Re: Cobbora Coal Project - Independent Groundwater Modelling Review

**PEER REVIEW OF THE COBBORA COAL
PROJECT GROUNDWATER ASSESSMENT**

Report Number: HC2012/5
Date: February 2012

Figure 4.5C Selected hydrographs showing observed versus calibrated transient groundwater heads

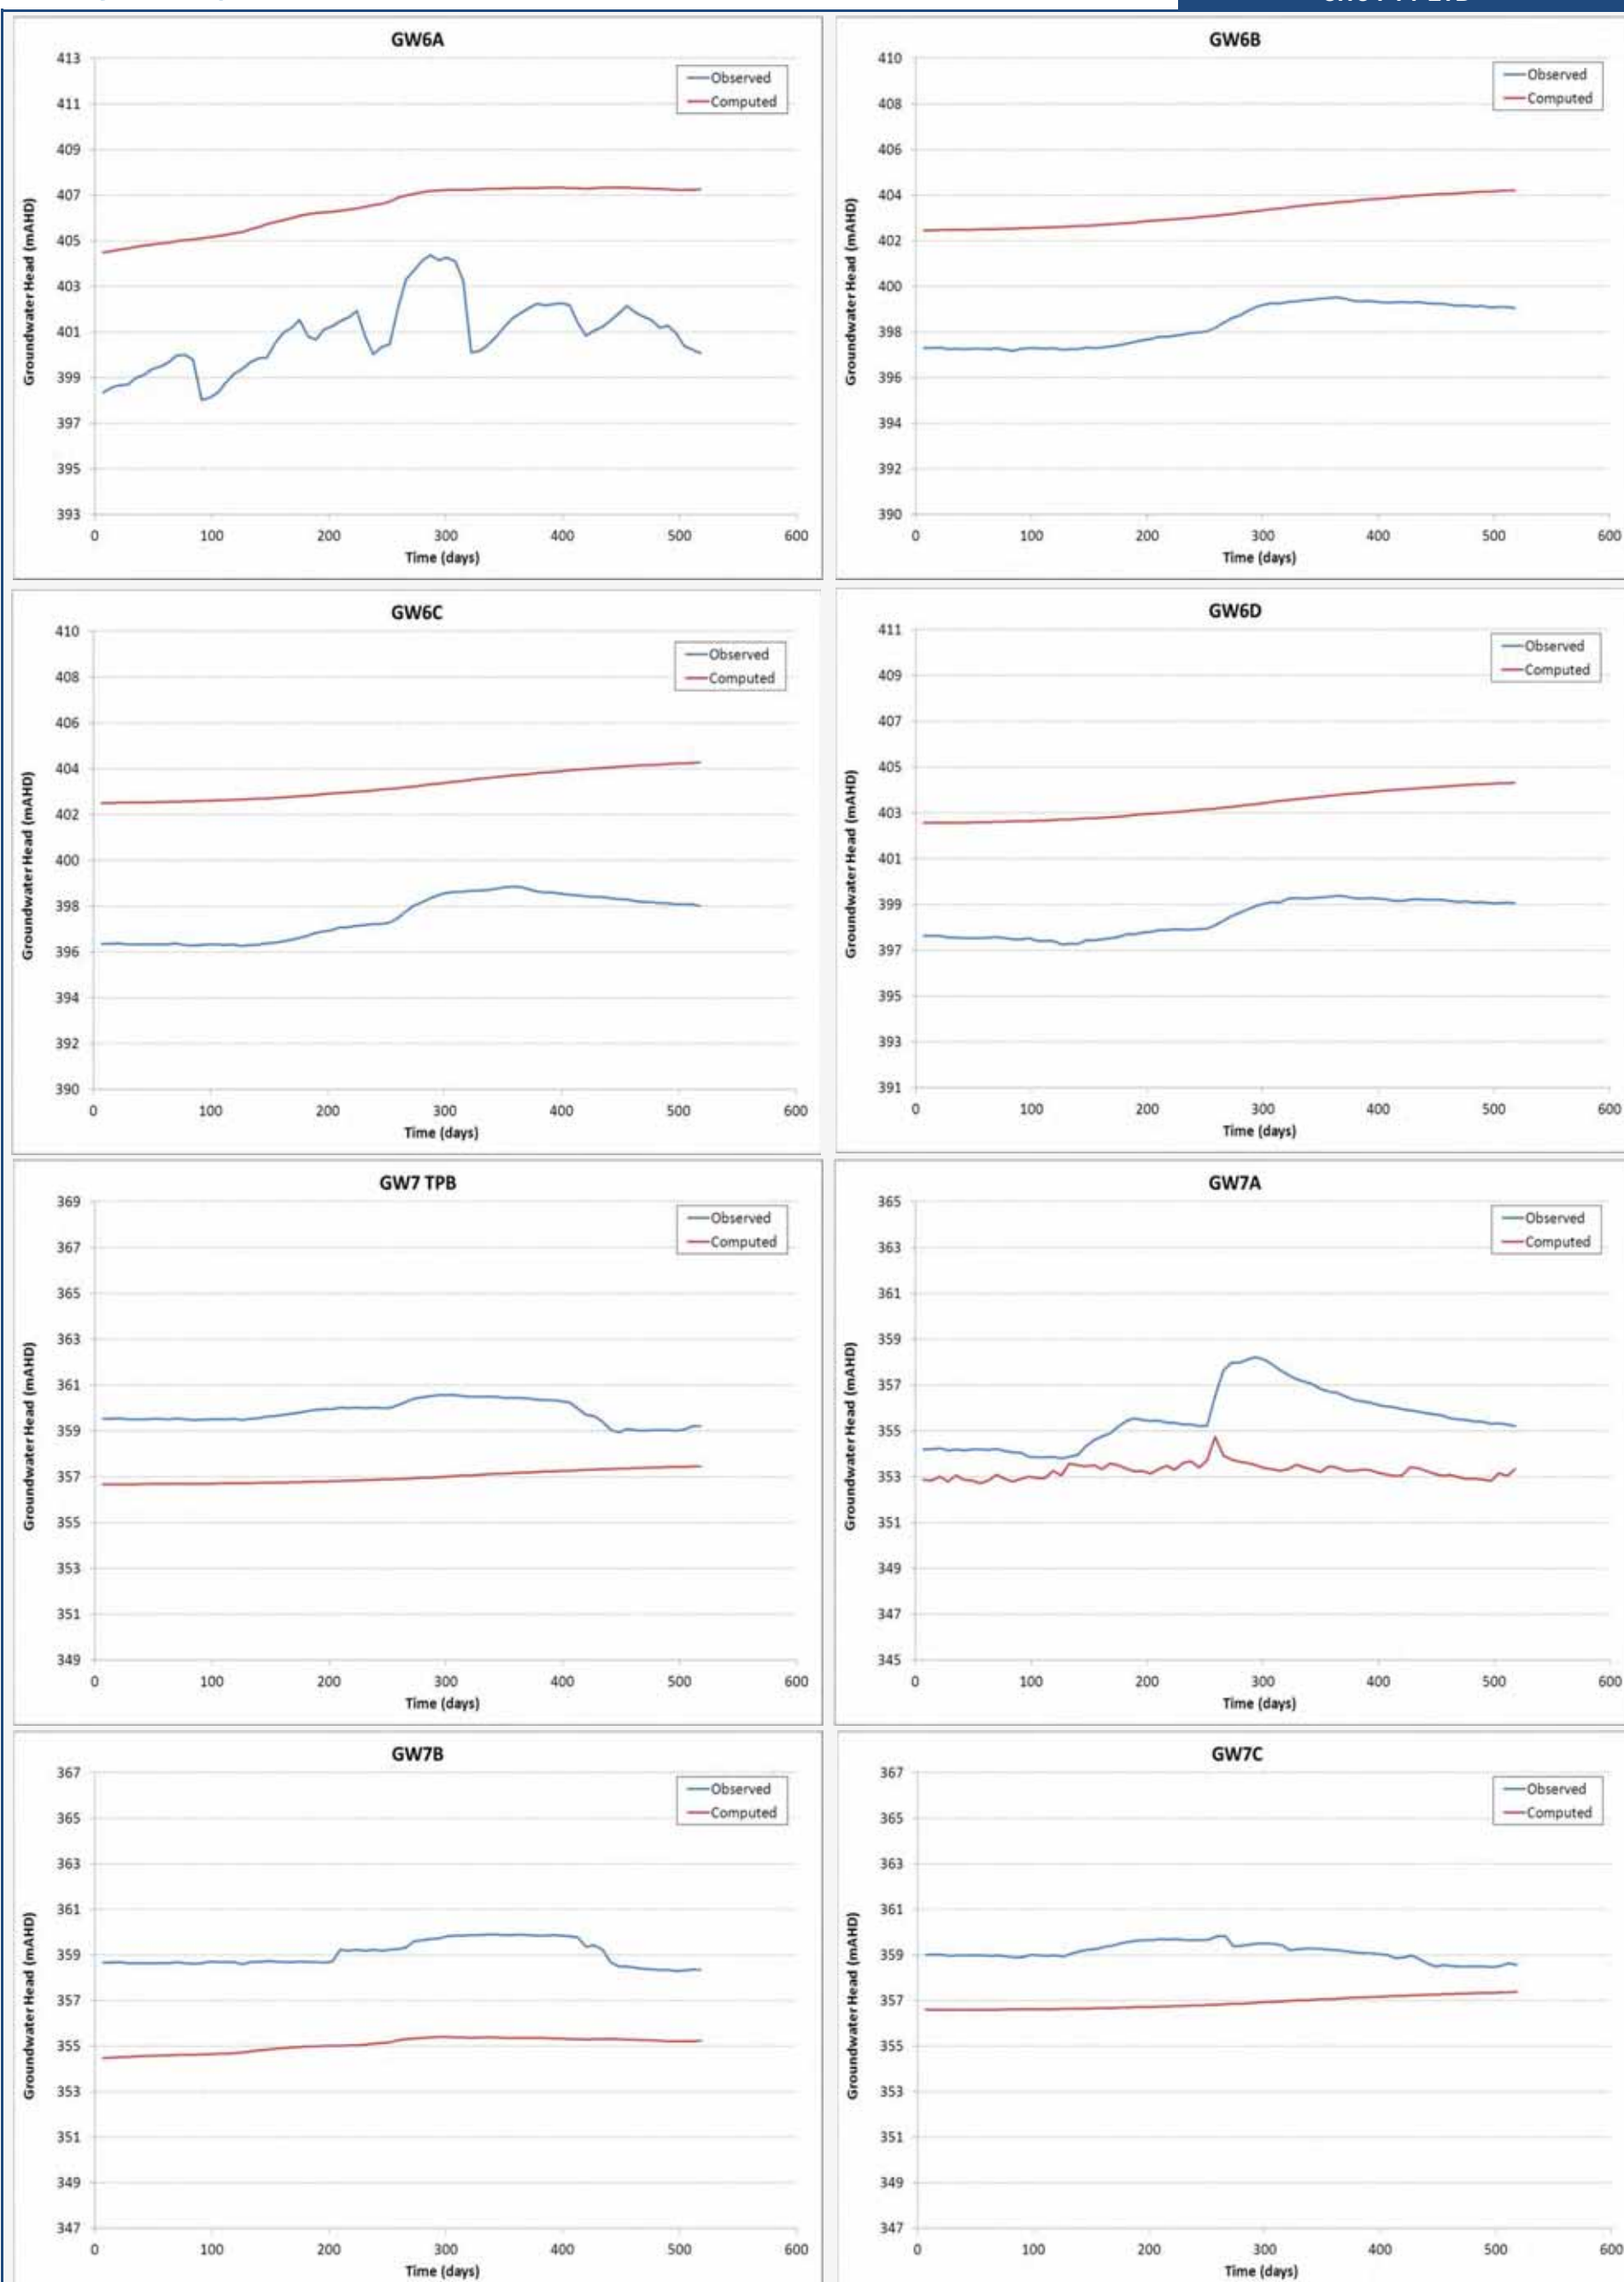
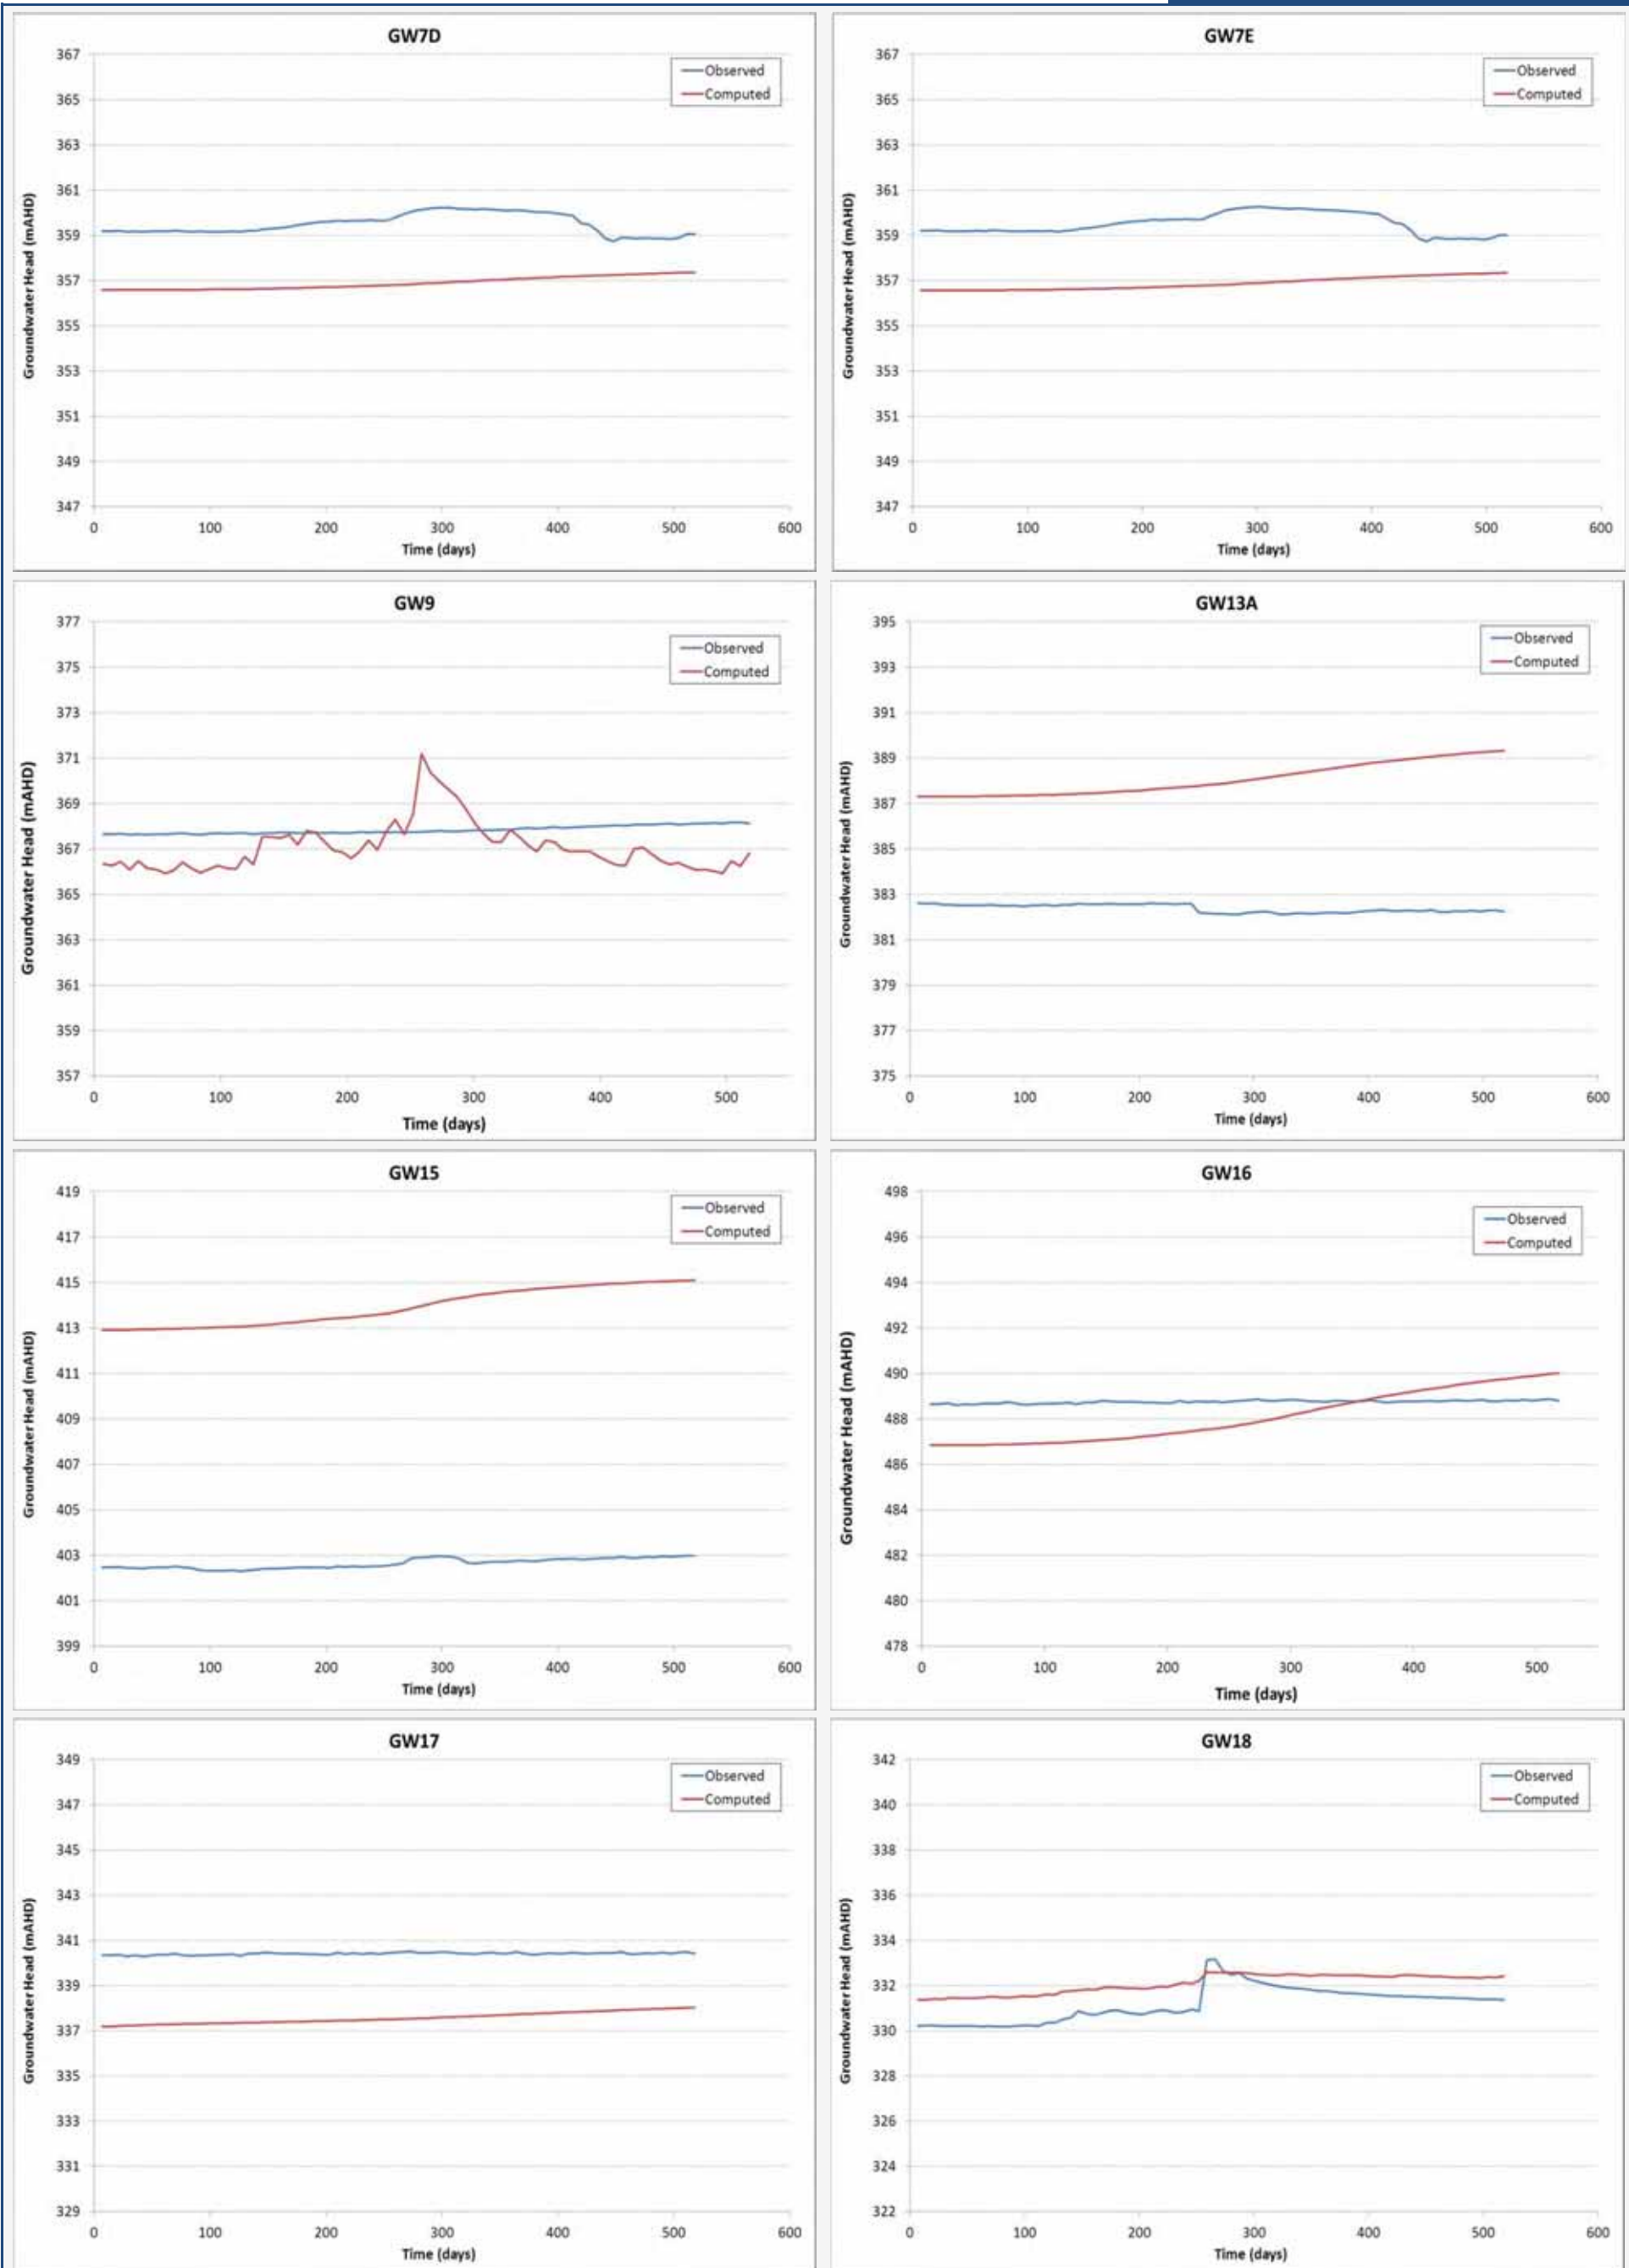
Transient calibration evidence is provided also by a scatter plot and RMS performance statistics, with examples of a few hydrographic matches. The transient performance is measured at 2.4 %RMS and 4.1mRMS, which is quite good. However, not all hydrographic matches are presented. Of the eight comparisons that are presented, only two are particularly good (in alluvium at Bore GW5A) and in the Digby Formation (at Bore GW5B). The others generally suffer from offsets in absolute value, although trends are

generally good. Without seeing the full set of hydrographic matches, or a residuals map, it is not possible to say which areas of the model are well calibrated or which natural processes are well replicated.
